# HOMESTEAD NORTH AT STERLING RANCH FILING 3

SECTION 27,28 AND 33, IN TOWNSHIP 12 SOUTH, RANGE 65 WEST OF  
THE 6TH PRINCIPAL MERIDIAN, EL PASO COUNTY, COLORADO  
**REZONE**

REZONE EXHIBIT

# Zoning Map\_v1.pdf Markup Summary 9-8-2022

HOMESTEAD NORTH AT STERLING RANCH FILING 3

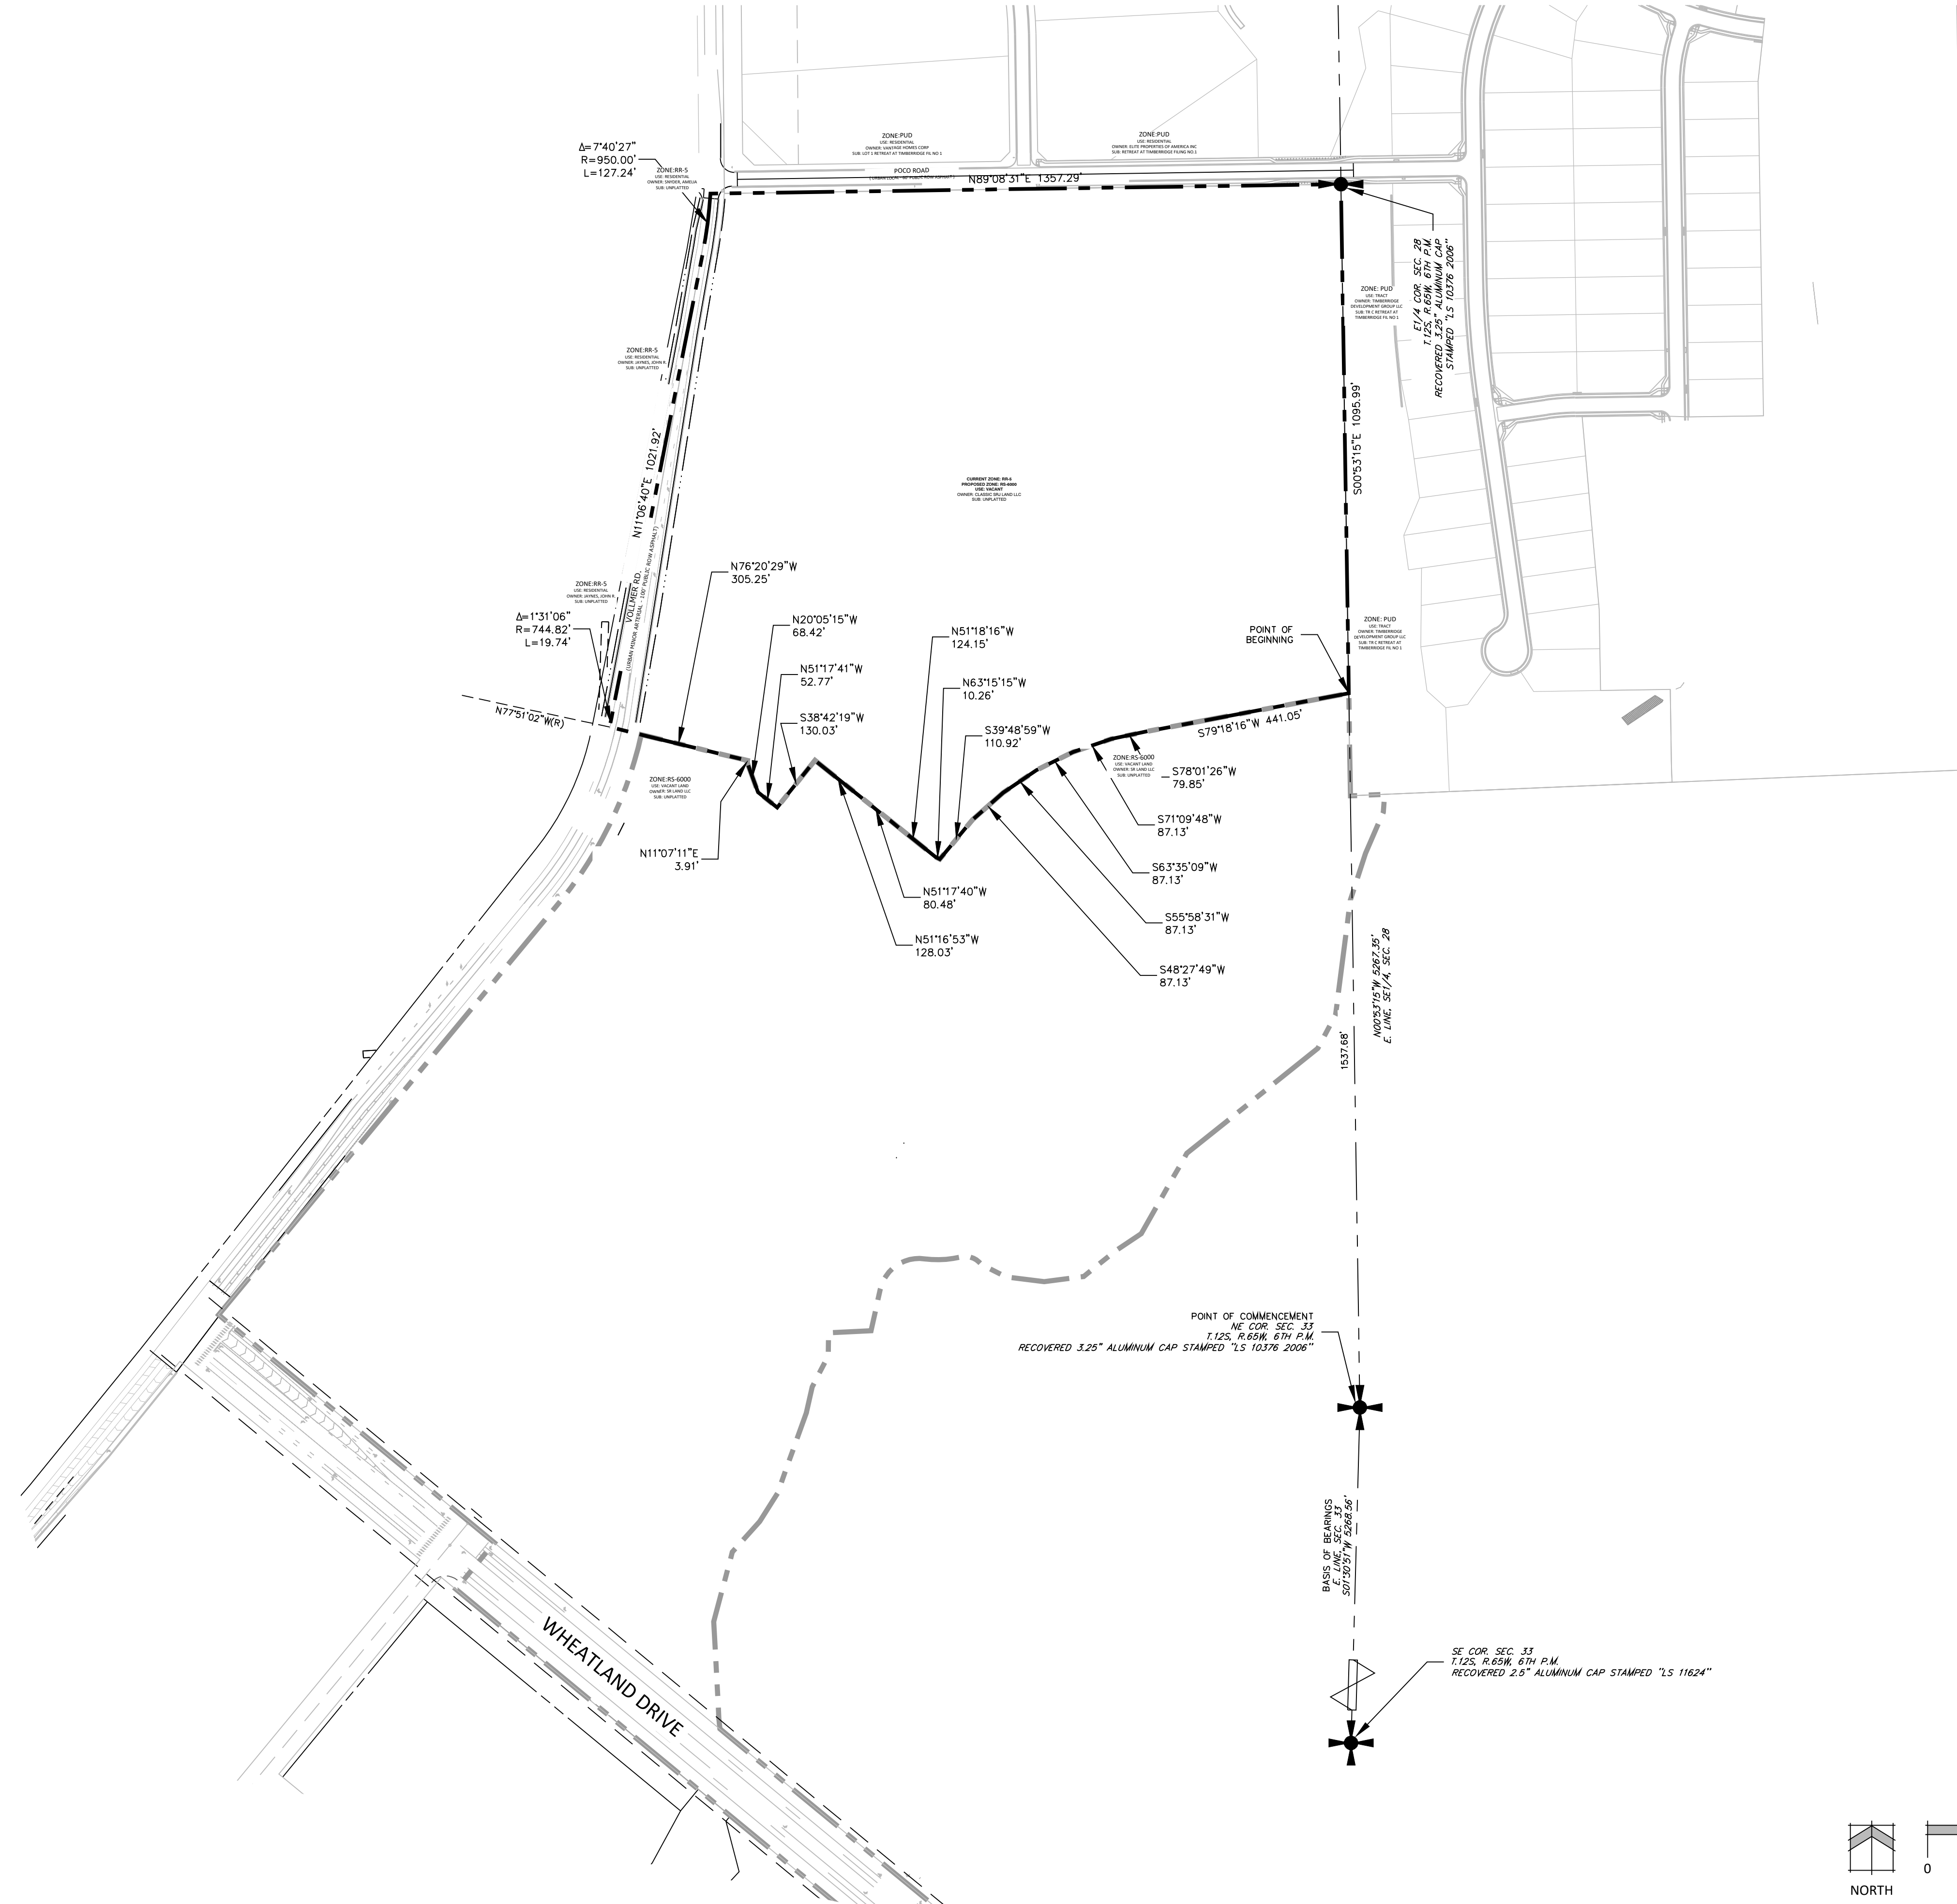
Boundary should go to centerline of road

Indicate point of beginning, point of commencement & basis of bearing

Turn off future development

if this was included in the Retreat at TimberRidge we dont need to do that as long as we dont have a sliver off RR5 between the PUD and proposed RS6000
